**Mark Speakman**  
Minister for Heritage

**Campbell's Stores, The Rocks – Application SSD 7056**

I write to raise my concerns in relation to the proposed new structure at Campbell's Stores, The Rocks, known as Bay 12.

01 NORTH-WEST ELEVATION
SCALE 1:50

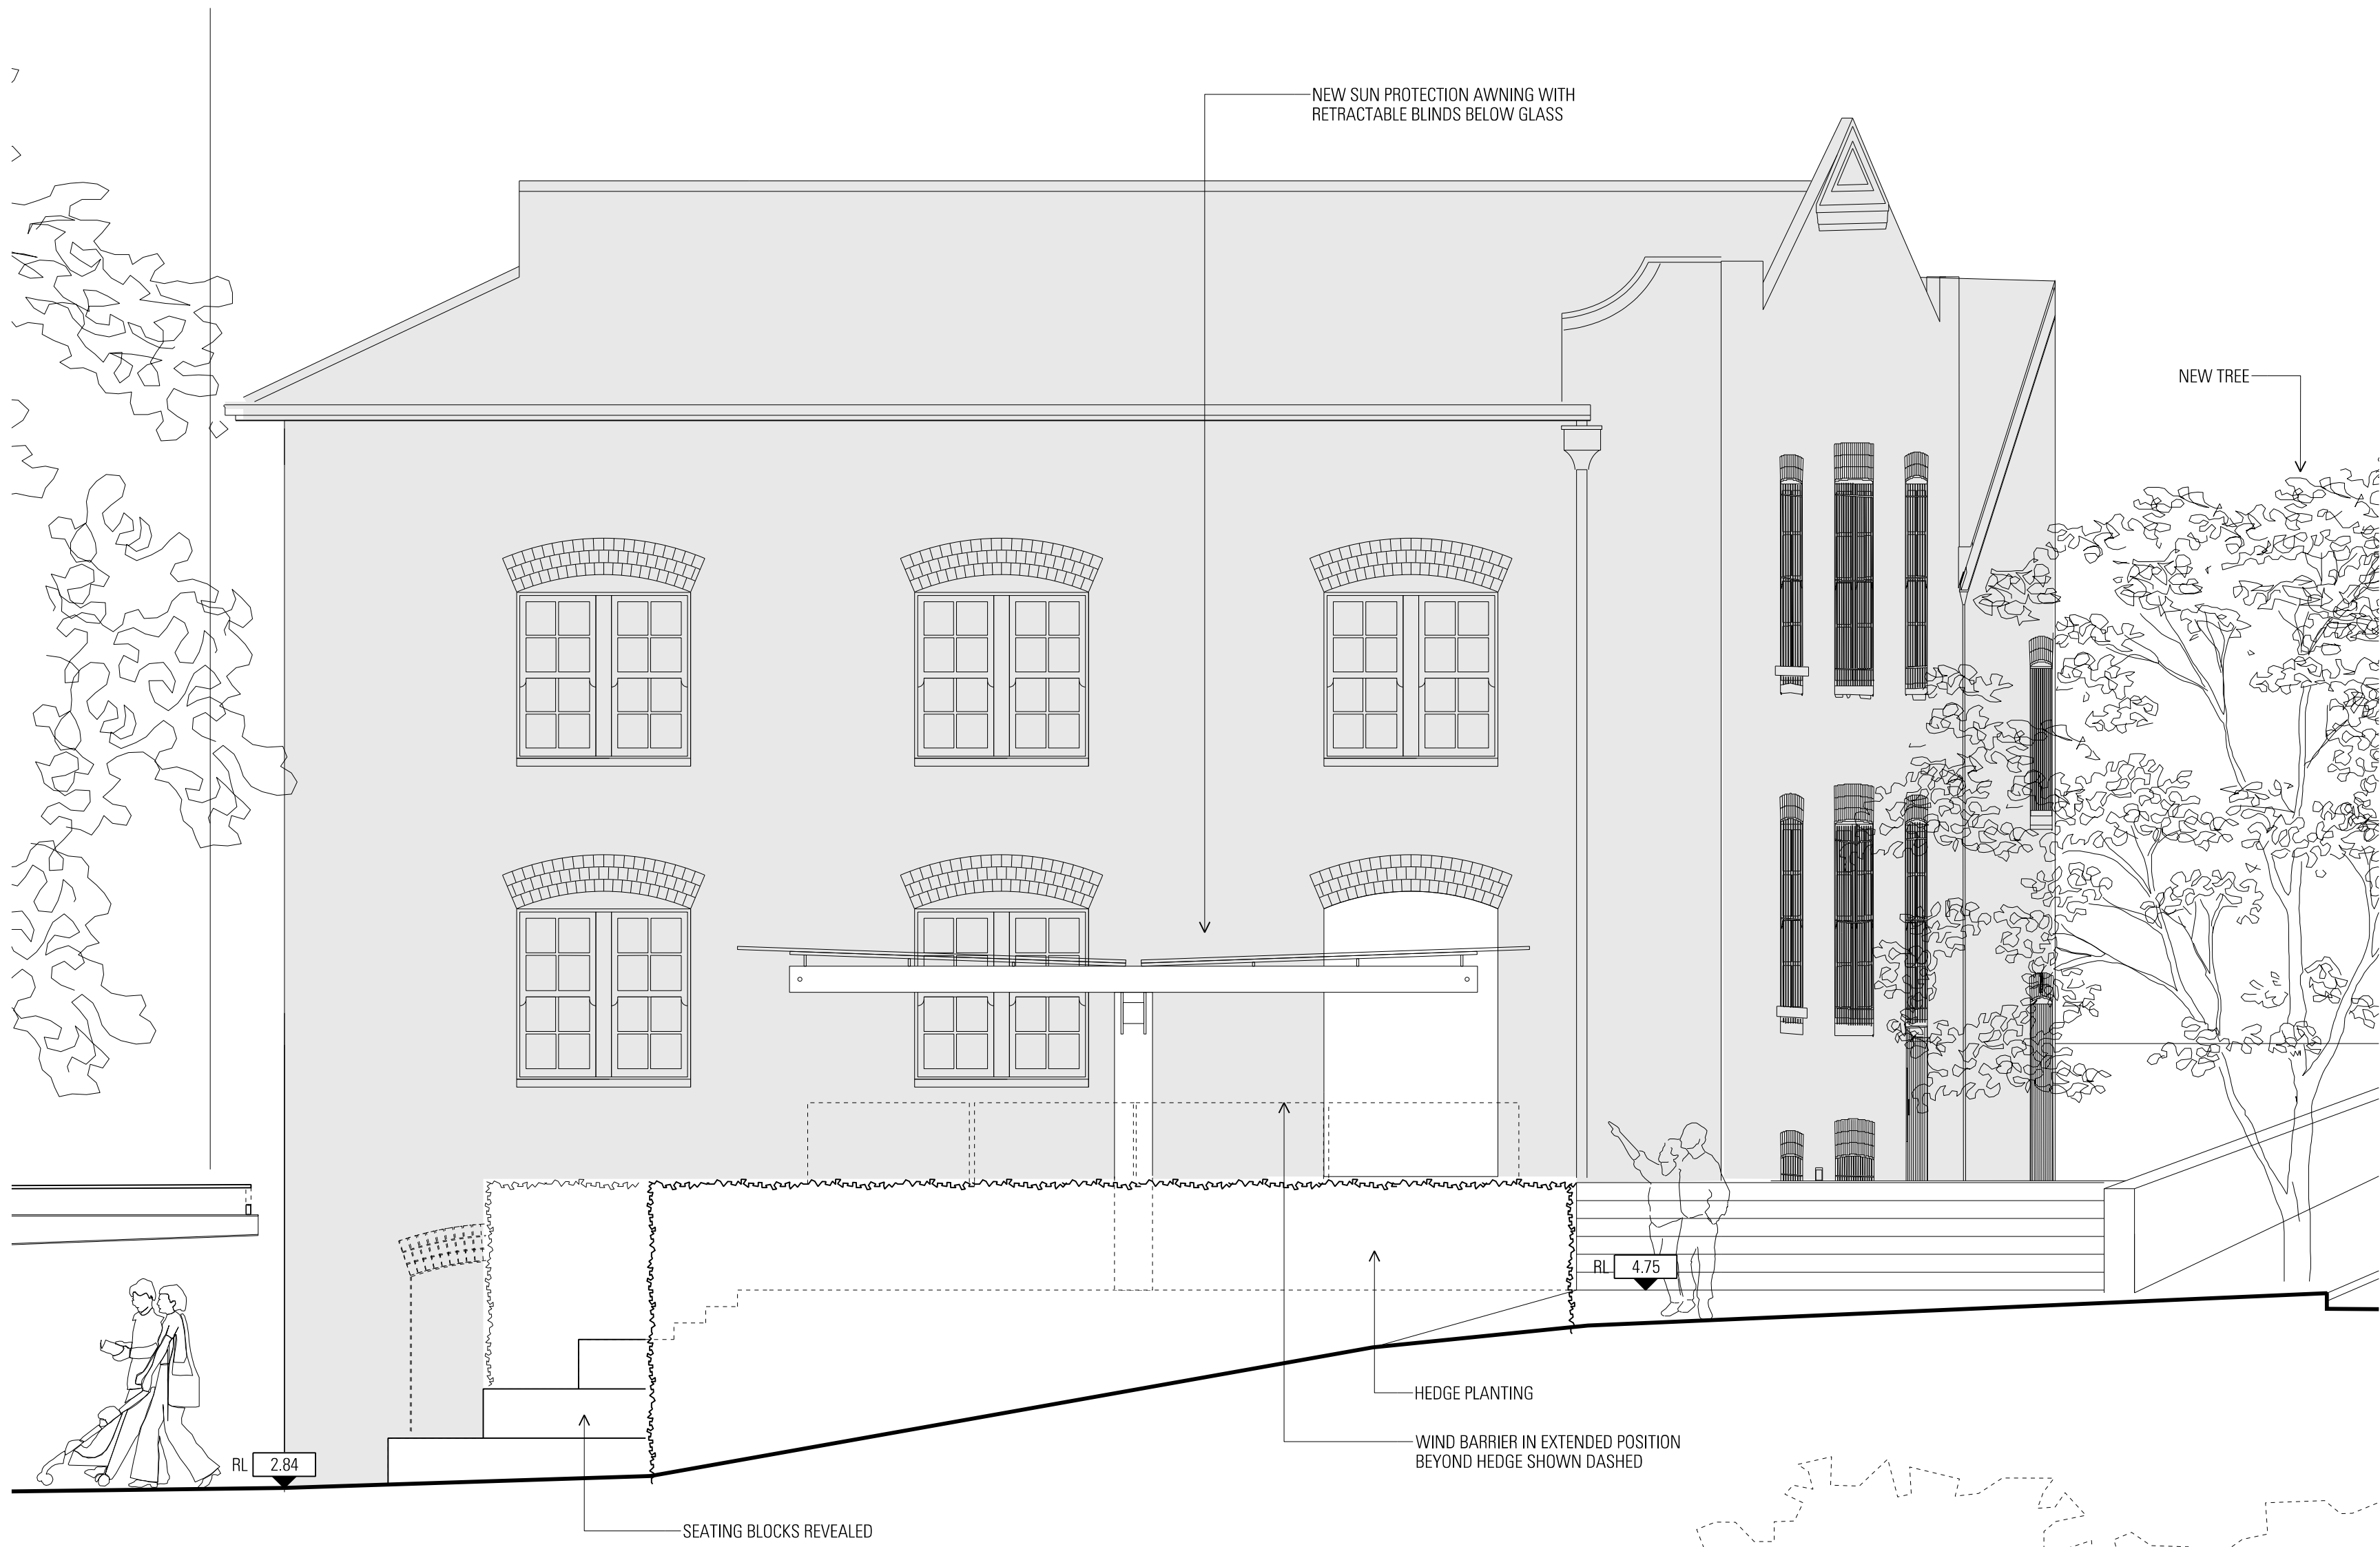
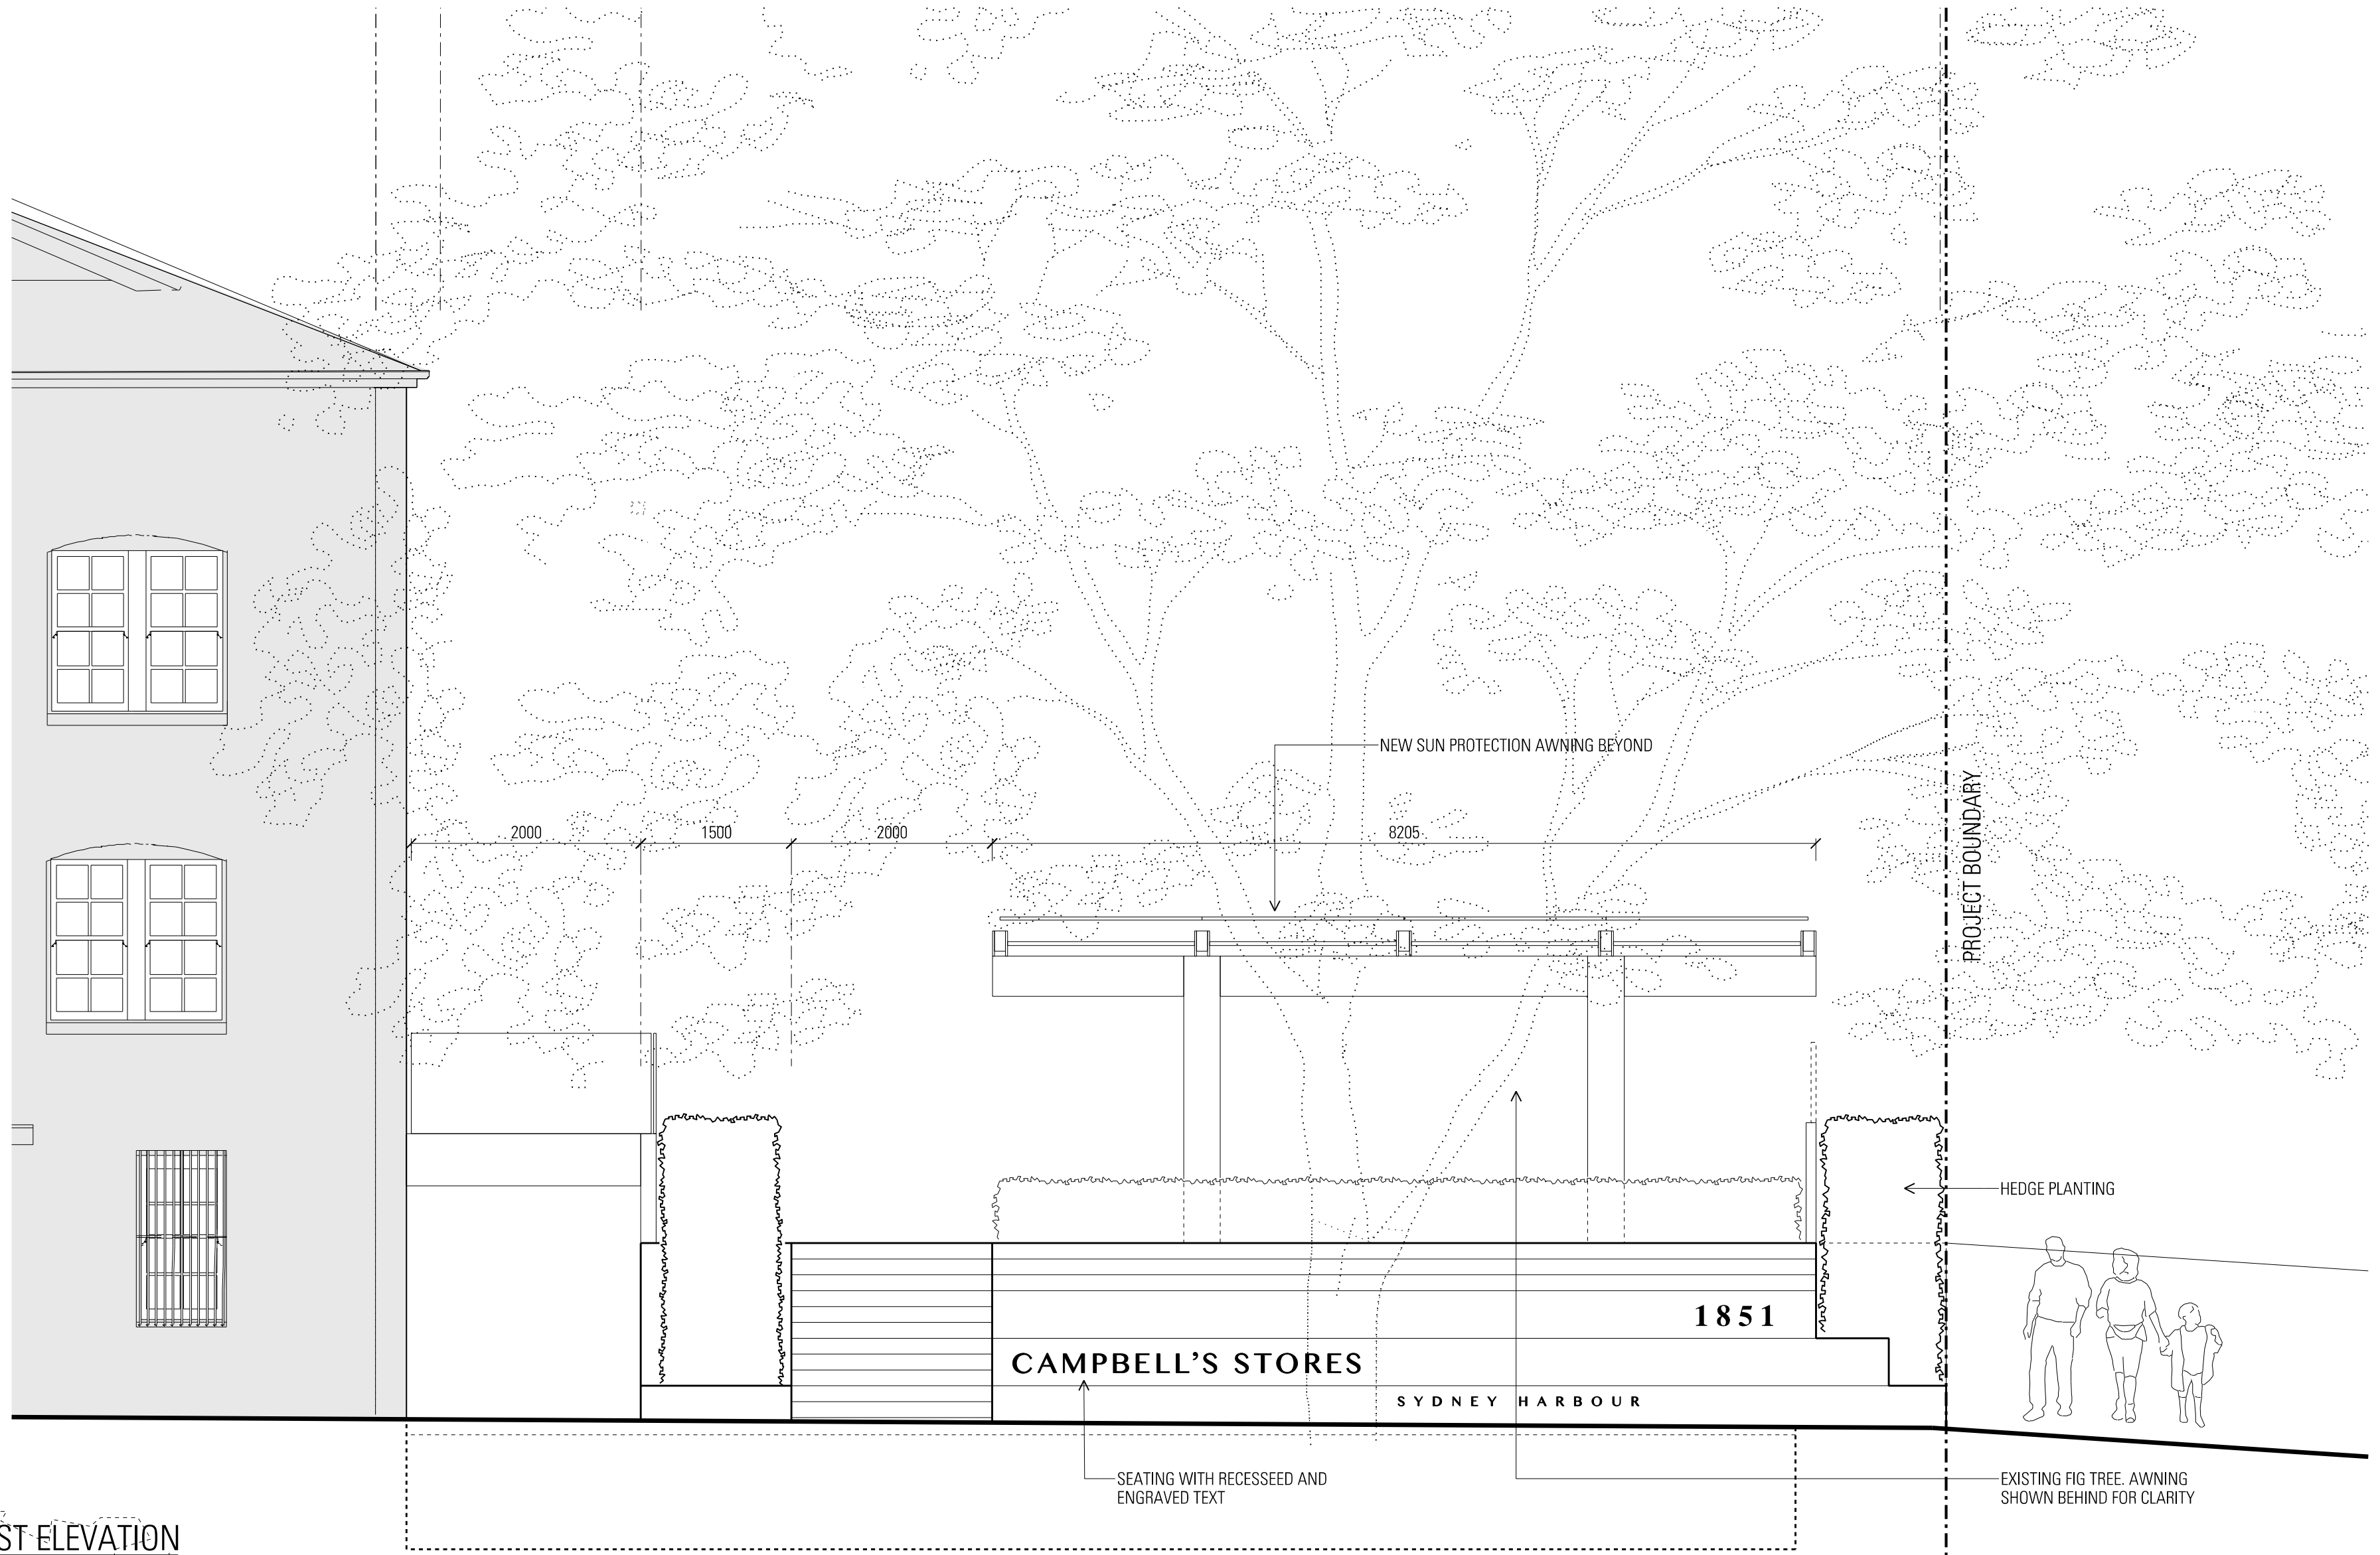
The discordant appearance of the proposal does not meet the guidance within *Design in Context* on built form. *Design in Context* states:

The argument is strengthened when considering the streetscape. The form proposed does not respond to the prevailing ground floor and roof line, which are critical to the street presence defined by load-bearing masonry walls with few, regular openings. *Design in Context* supports such an approach:

The building aligns with the street which is appropriate; however this is undermined by the treatment of the street edge, where the lack of a solid ground façade due to the raised structure undermines the streetscape.

In this case, the modern materials proposed are not proportioned or detailed in a way that is harmonious with the surrounding historic context – rather than unifying through patterns of contrast, it provides mere contrast. Materials and colours are not used in way that protects context, but instead are materials which are preferred by the architect in their other work. The use of glass blocks is without any contextual grounding, and seems more about imitating their use in other high-end retail developments. Despite a gesture to utilising warmer hues, this does not address the core issue of material choice.

*Design in Context* does provide significant freedom to utilise such detailing, and introduce new materials where appropriate in a way which contributes positively to the character of the place. The proposal here, however, does not engage with the key patterns of detailing that are characteristic of the precinct. By lacking a ground floor, the solidity and texture of masonry which give balance and frame the street are absent. The simply framed openings for doors and windows are negated by the absence of windows and doors.
